7 December 2012
Our Ref: 24163 KAR
Your Ref: MP05_0024

**REQUEST TO MODIFY A DEVELOPMENT APPROVAL UNDER SECTION 75W OF THE EP&A ACT –
MAJOR PROJECT 05_0024 FOR A STAGED 102 LOT RESIDENTIAL SUBDIVISION – LOT 171
DP 1081810 HIGHVIEW DRIVE DOLPHIN POINT FOR MALBEC DOLPHIN POINT PTY LTD**

The Allen, Price & Associates plans provided to you 28 June 2010 have been slightly modified to number each lot in each stage however, submitted engineering plans prepared by Storm Consulting and Landscape Plans prepared by HW Smit have not been amended, therefore the attached plan (24163-21 Revision 07, dated 16.11.12) represents the latest information in relation to our modification request.

PROPOSED RESIDENTIAL SUBDIVISION

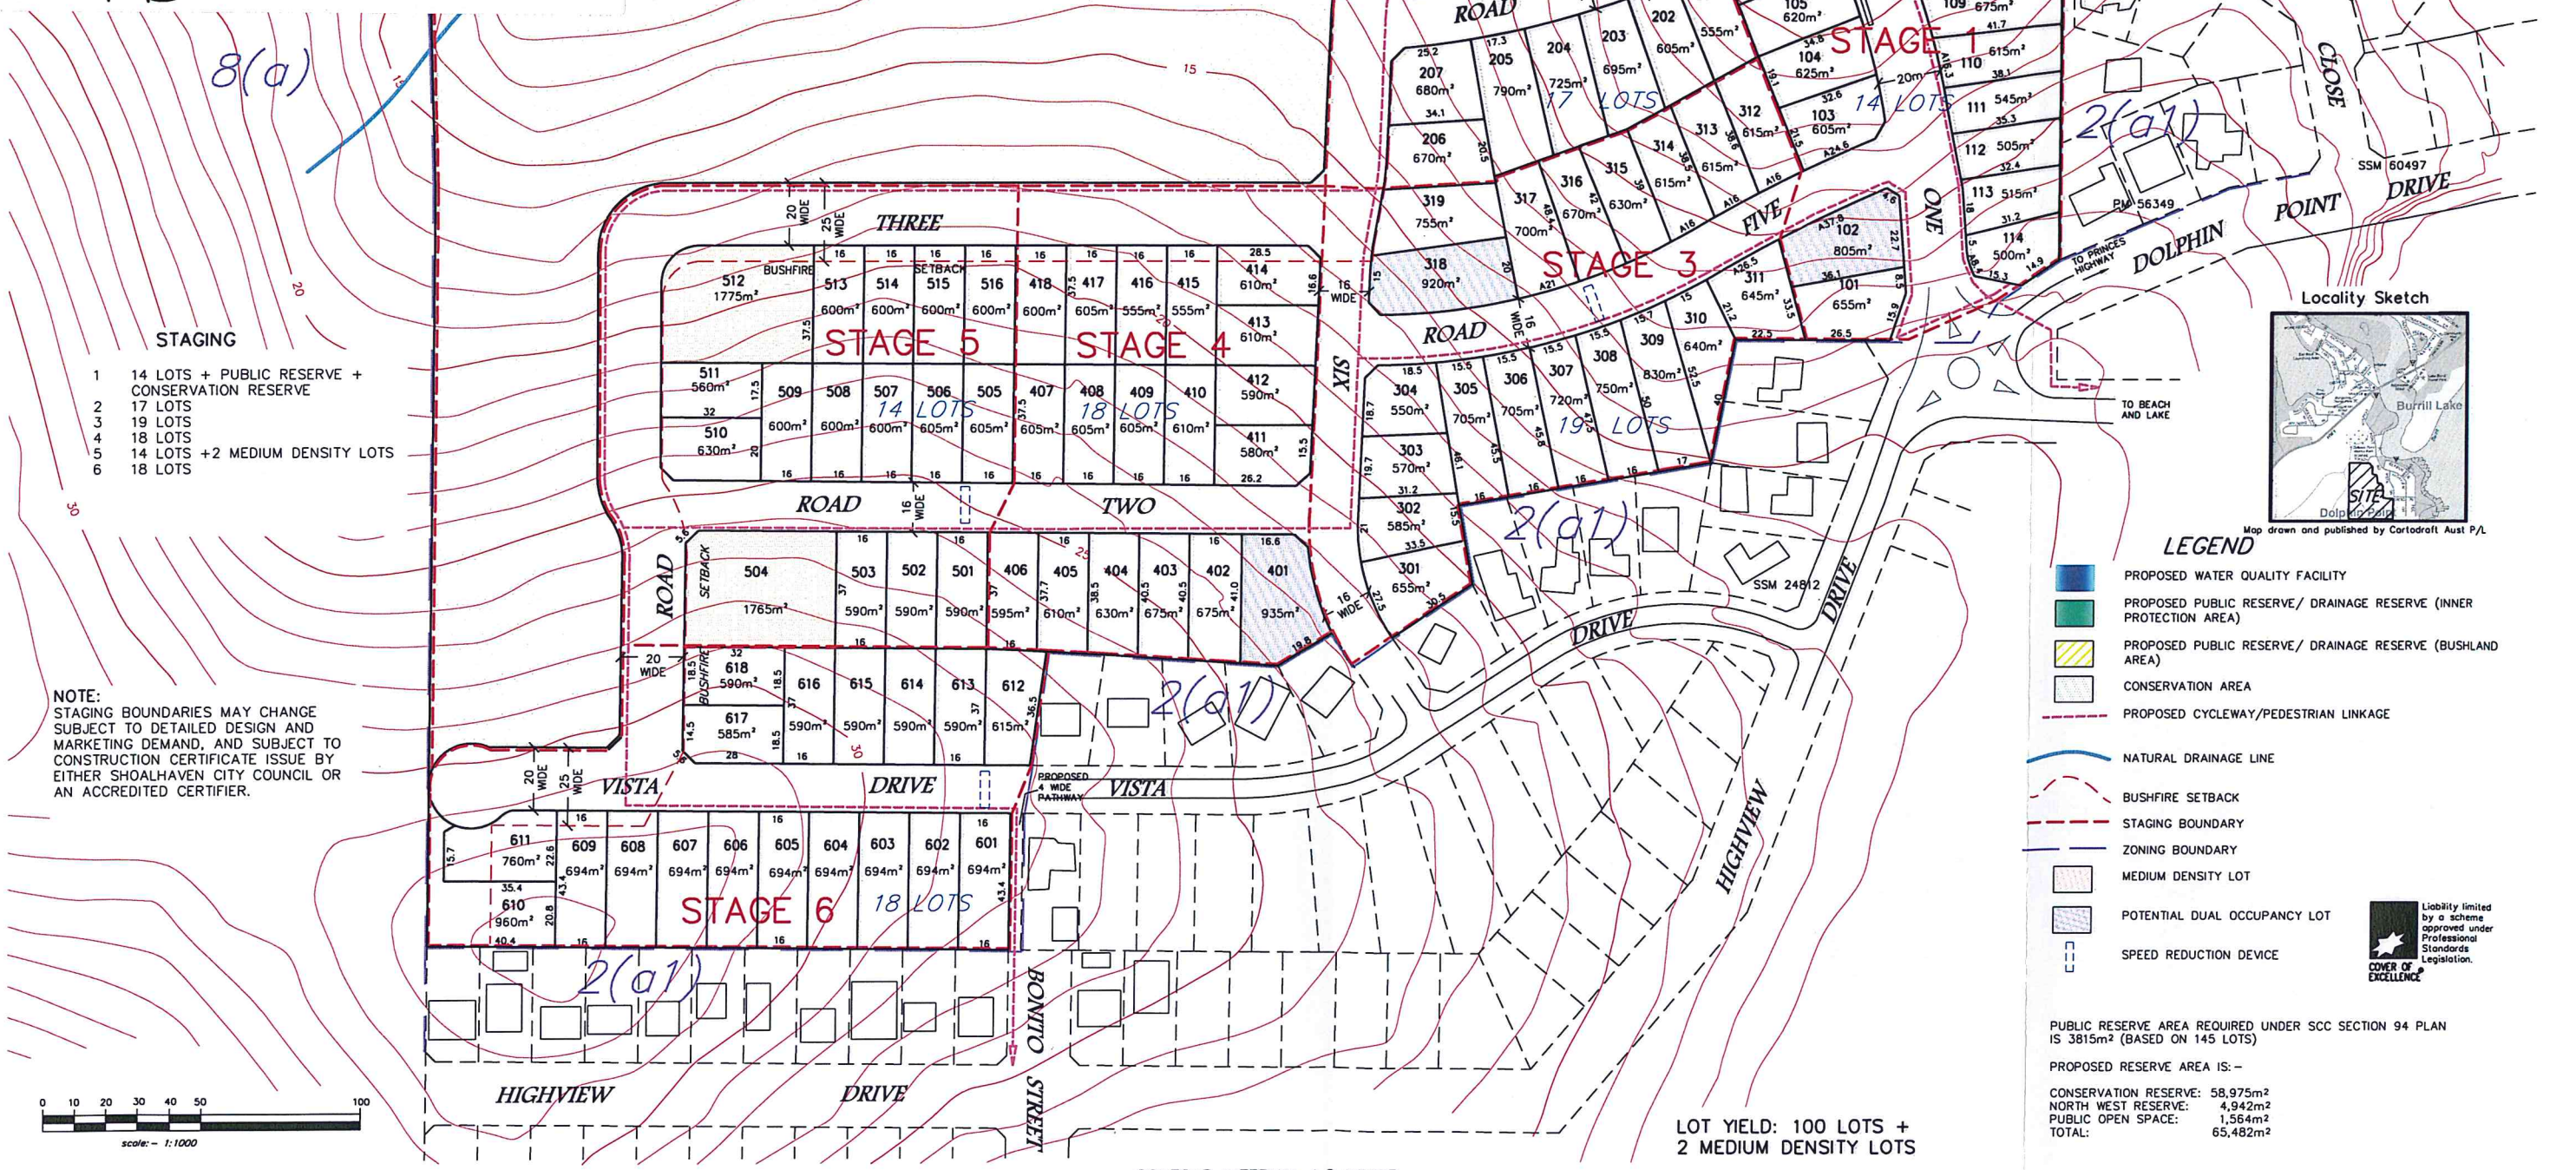
The changes on our most recent application sketch (24163-21 Rev 07 dated 16.11.2012) reflect numbers for each lot that are consistent with the staging of that particular section of the subdivision – e.g. – Stage 1 lots are numbered 101 – 114, and Stage 2 – 6 are similarly consecutively numbered.
